# CITY OF ALBUQUERQUE

RE: **Tract A-3-B (Legacy at Journal Center)**  
**Grading Plan**  
**Engineer's Stamp Date 4/26/17 & 3/29/17**  
**Hydrology File: D17D106A**

Based upon the information provided in the submittal received on 4/27/17 the above-referenced Grading Plan is not approved for Building Permit. The below item must be addressed prior to approval:

C-100

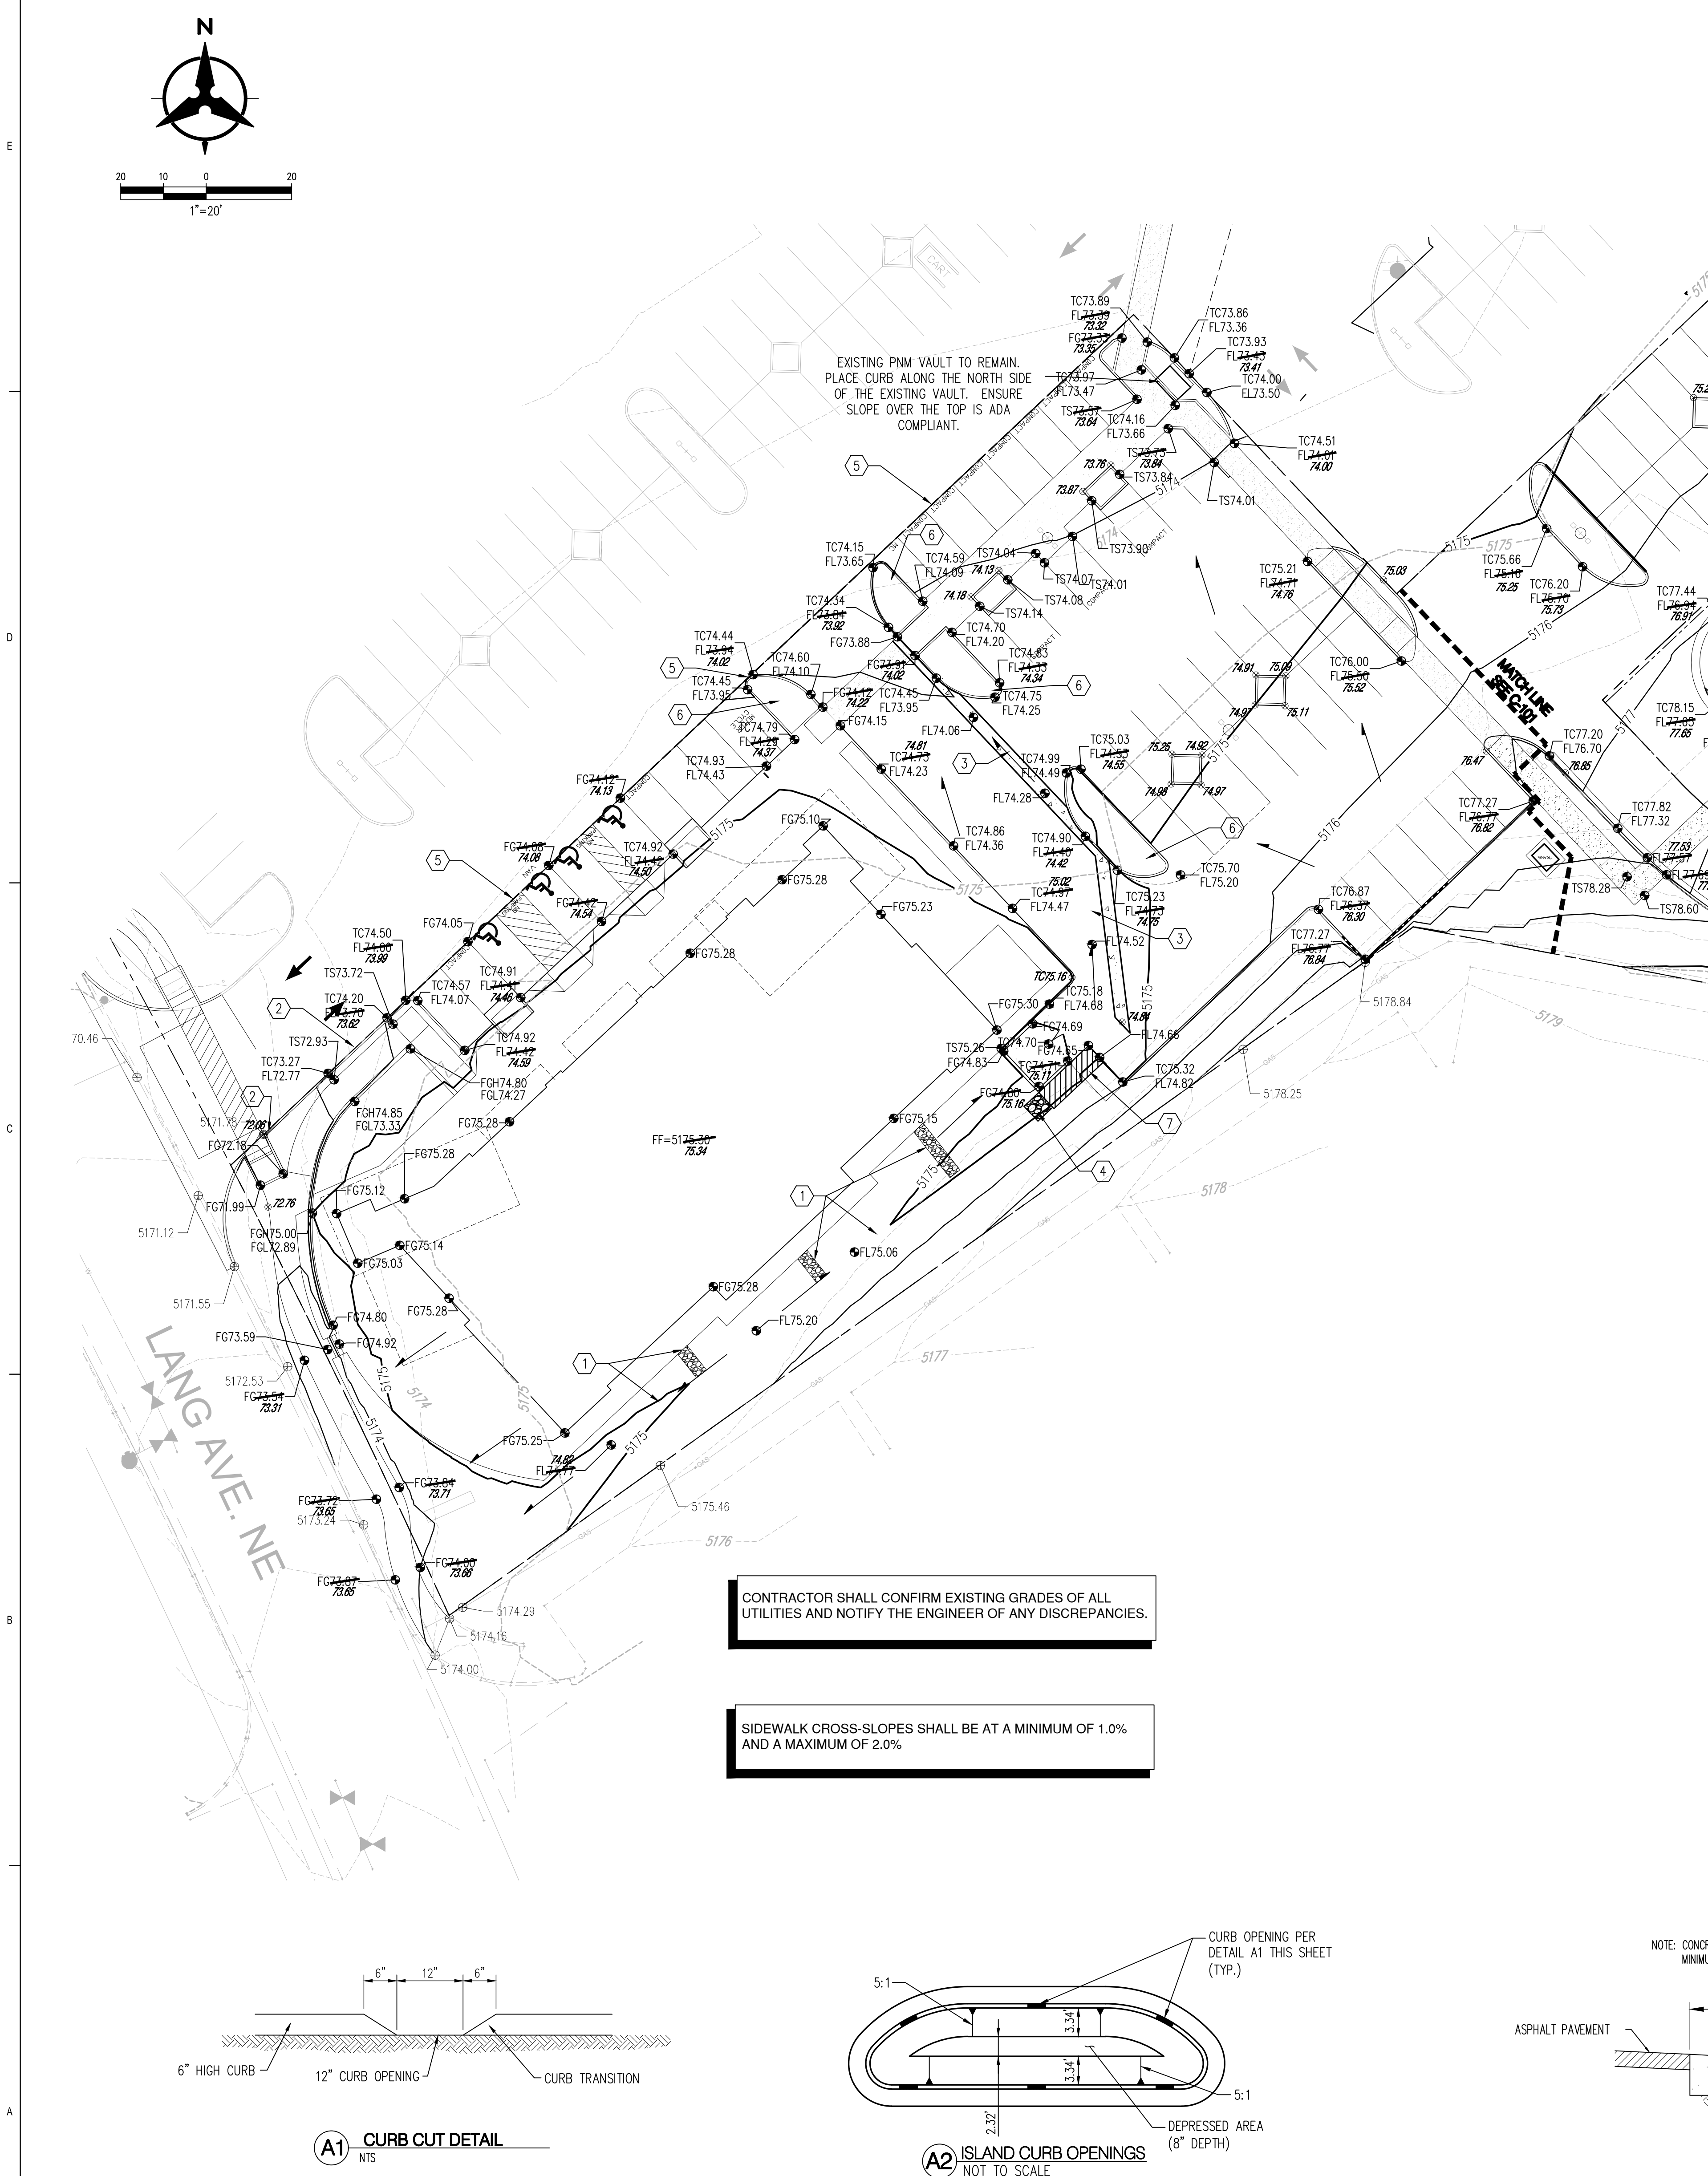
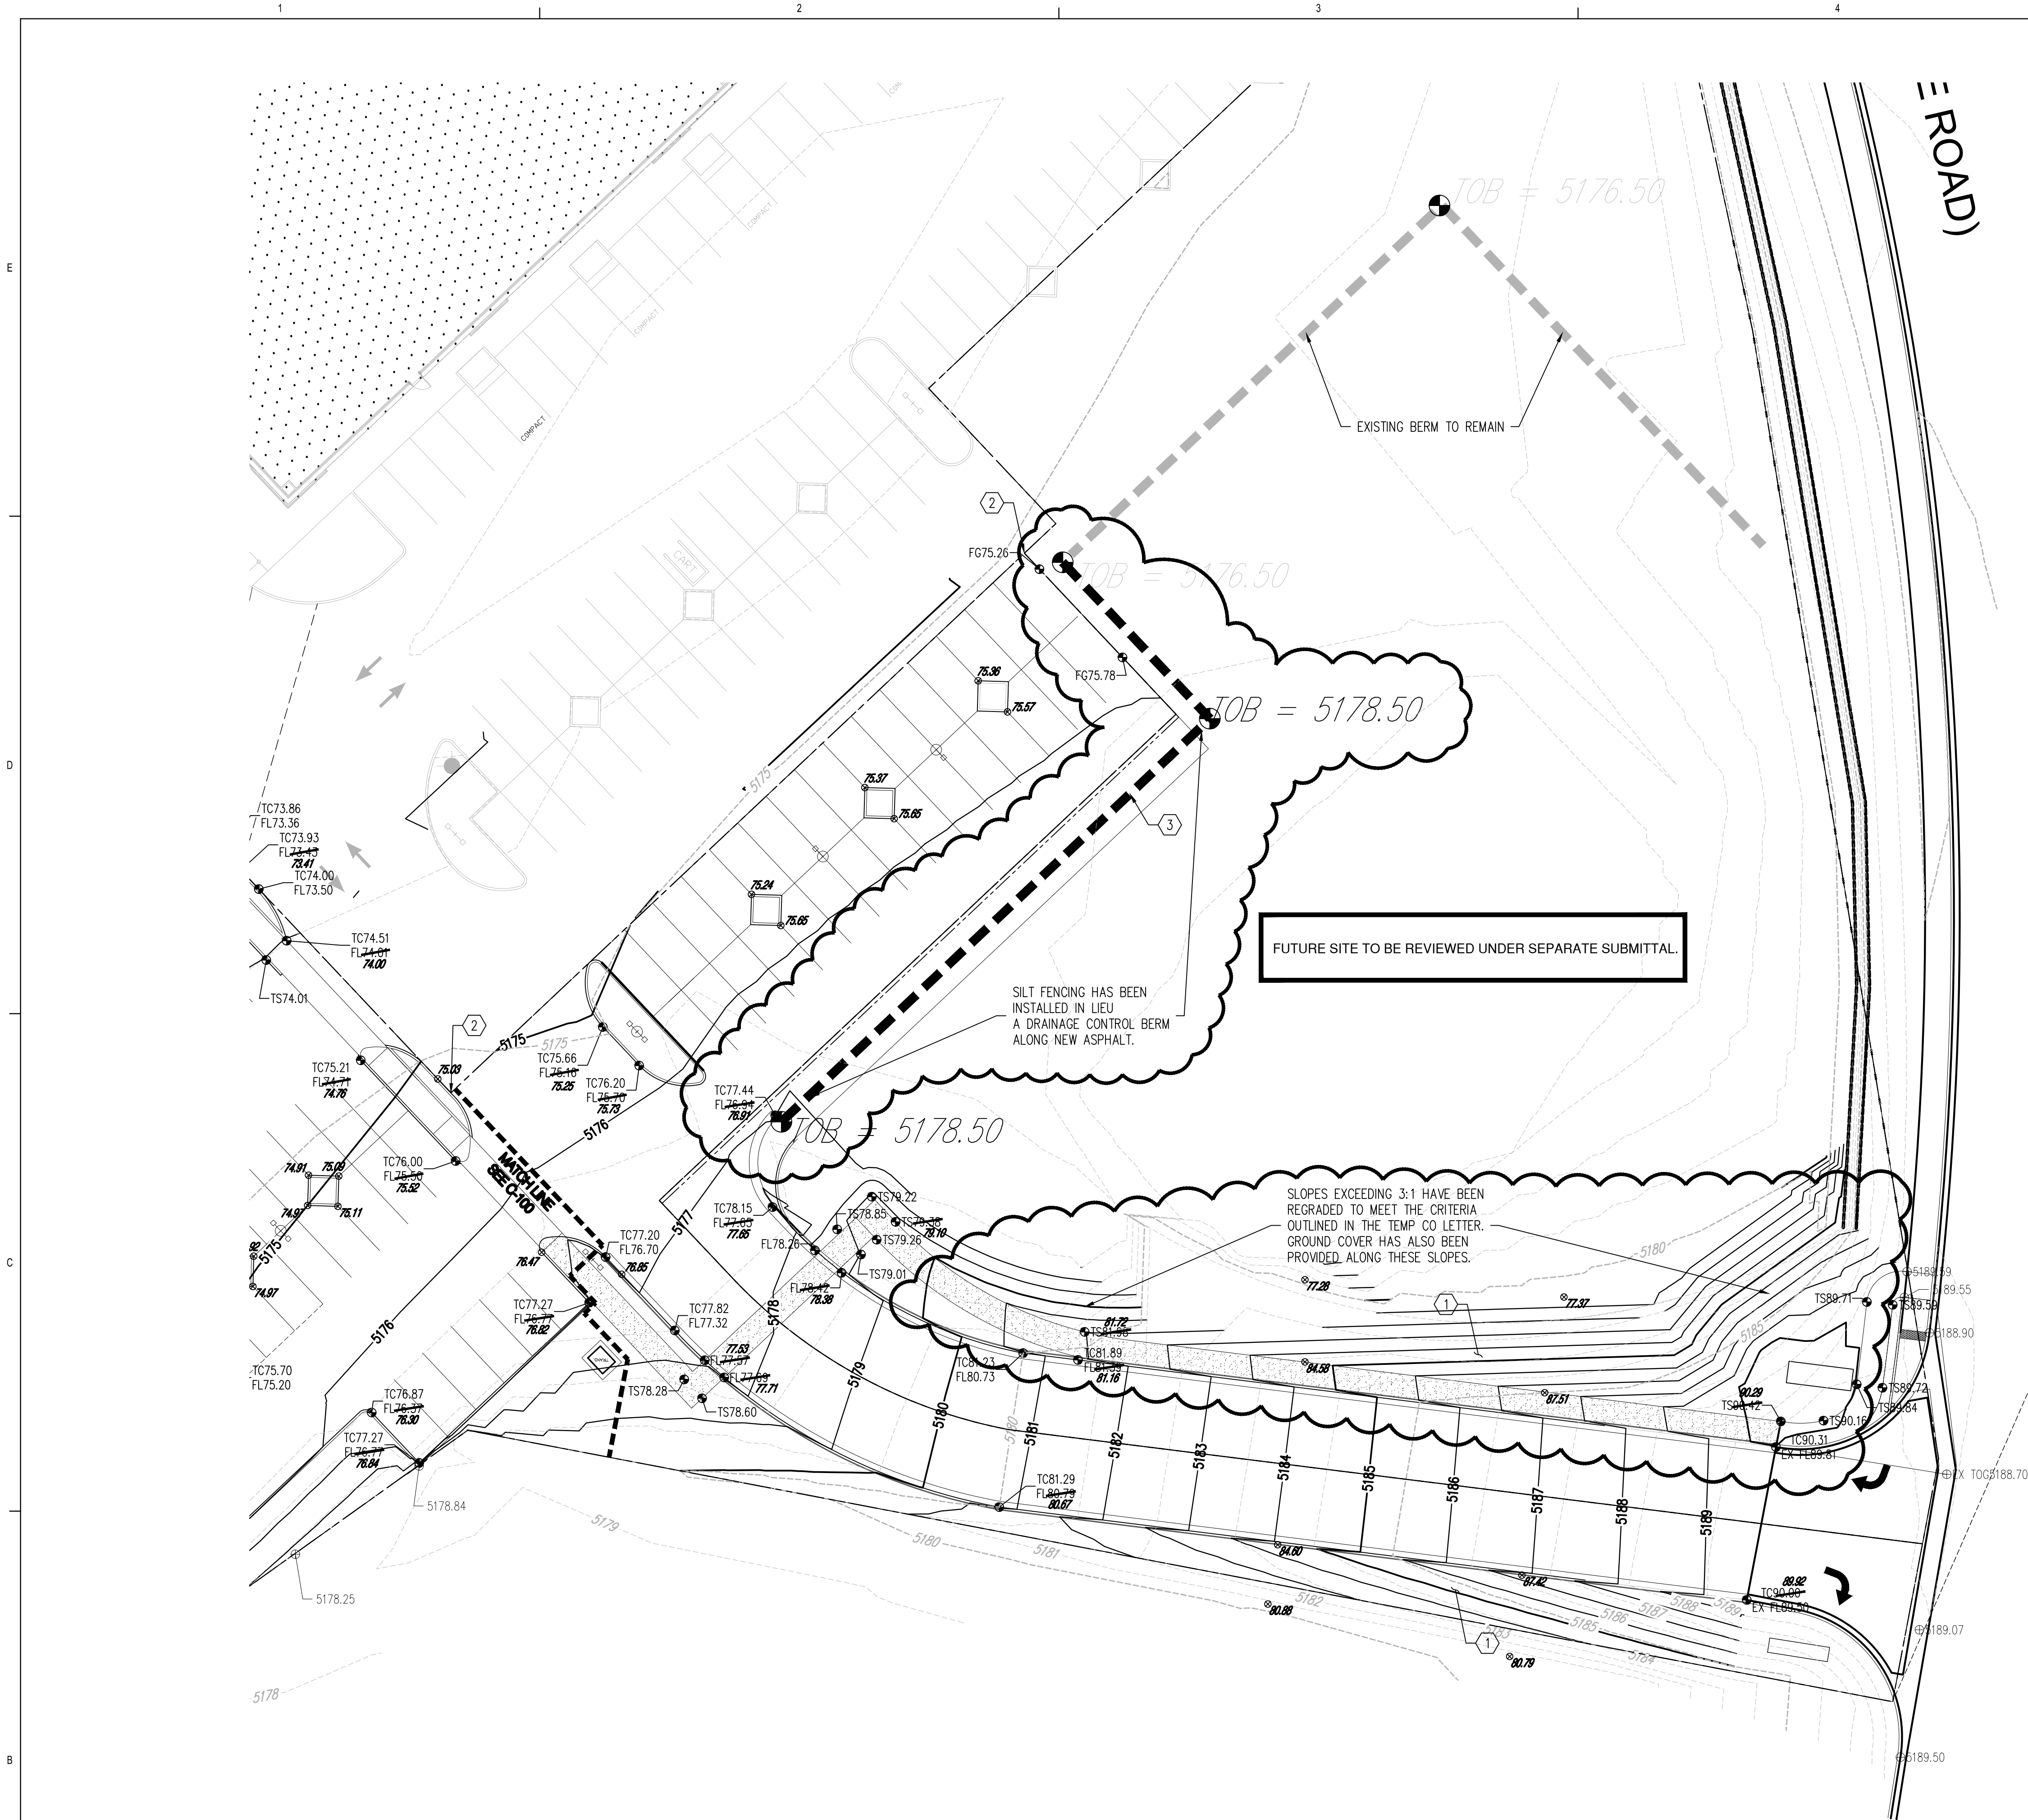
1. Provide an updated Drainage Management Plan (sheet C-001) that includes the limits of this project. Also include the revised limits and narrative for Basin B1-C that will now drain to Lang (this sheet was missing from the 4/26/17 paper submittal).
2. This project will require an ESC Plan to be submitted to the storm water quality engineer, Curtis Cherne, PE, prior to Building Permit Approval.
